**PLANNING ACT 2008 : THURROCK POWER, PROPOSED THURROCK FLEXIBLE
GENERATION PLANT**

Historic England Deadline 3 Response

Confirmation of Historic England Comments at Deadline 3 12th April 2021.

Figure 1.1: Representative Viewpoint Locations

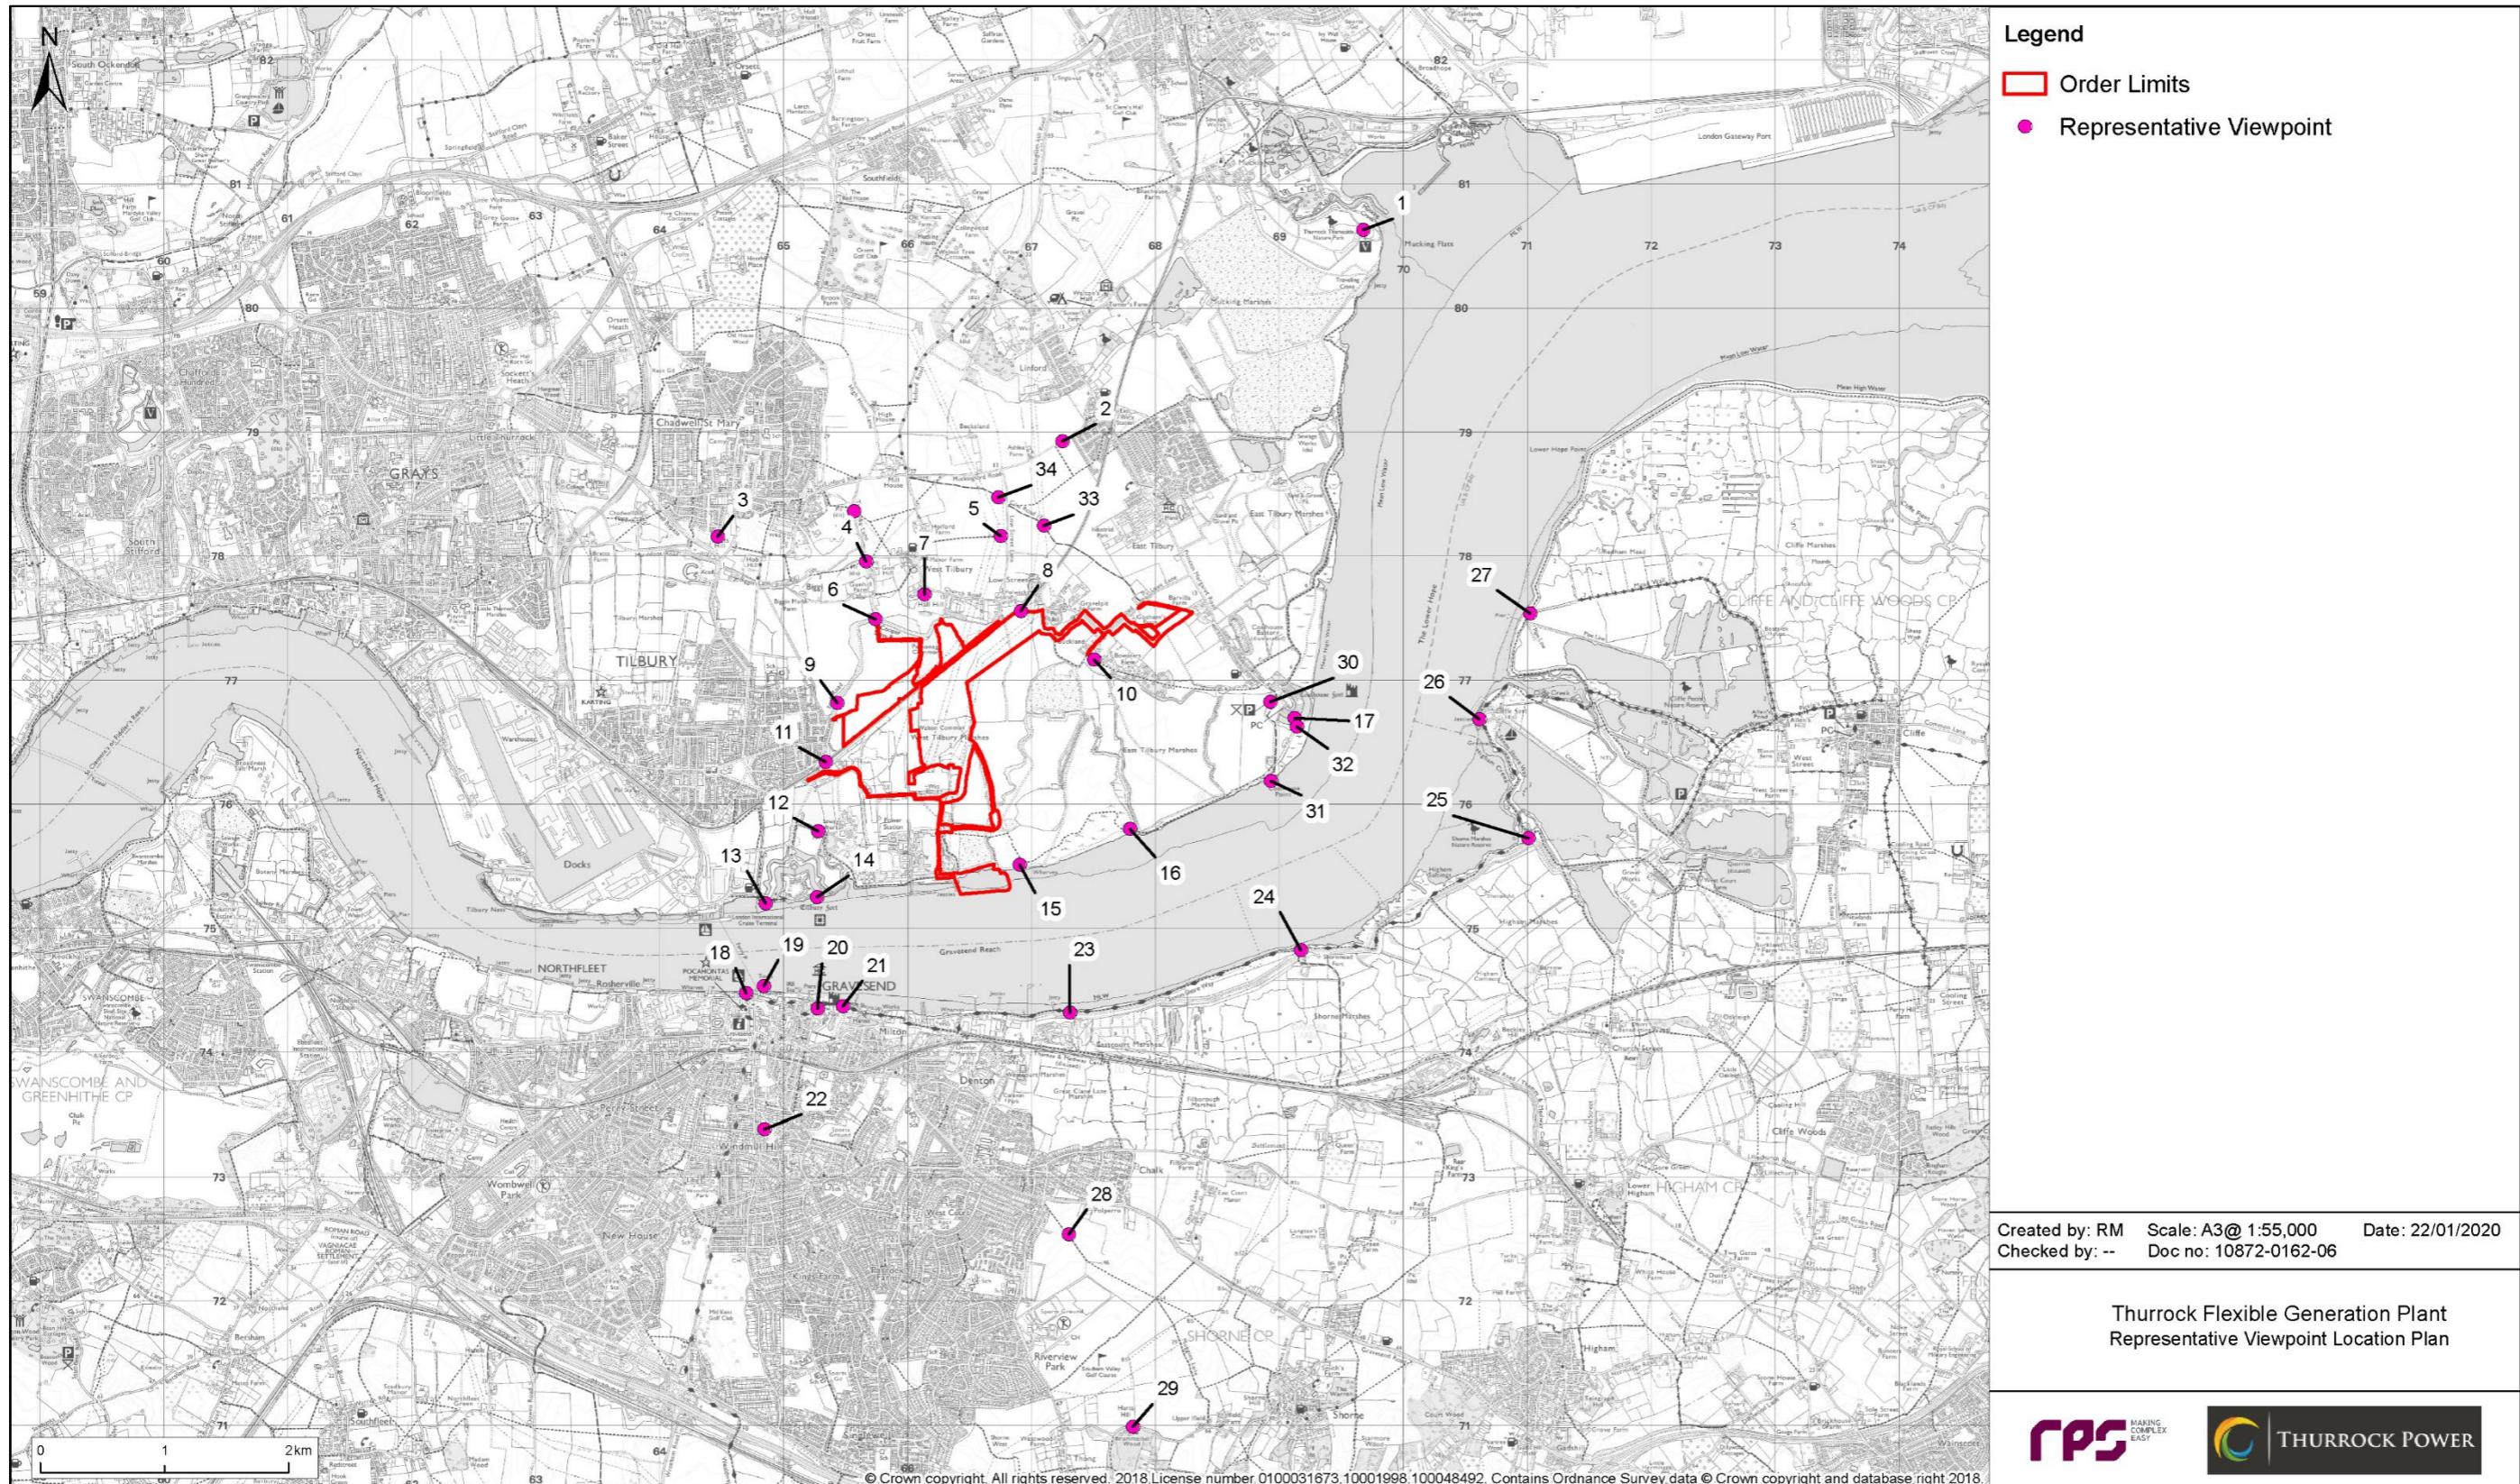
We acknowledge the additional visualisations that have been prepared for the raised embankment (sea wall) near viewpoint 31 and at St Katherine's Church. We are satisfied that these are adequate assessments for these viewpoints. We also agree that these demonstrate the impact on the significance of the heritage assets would be minor.
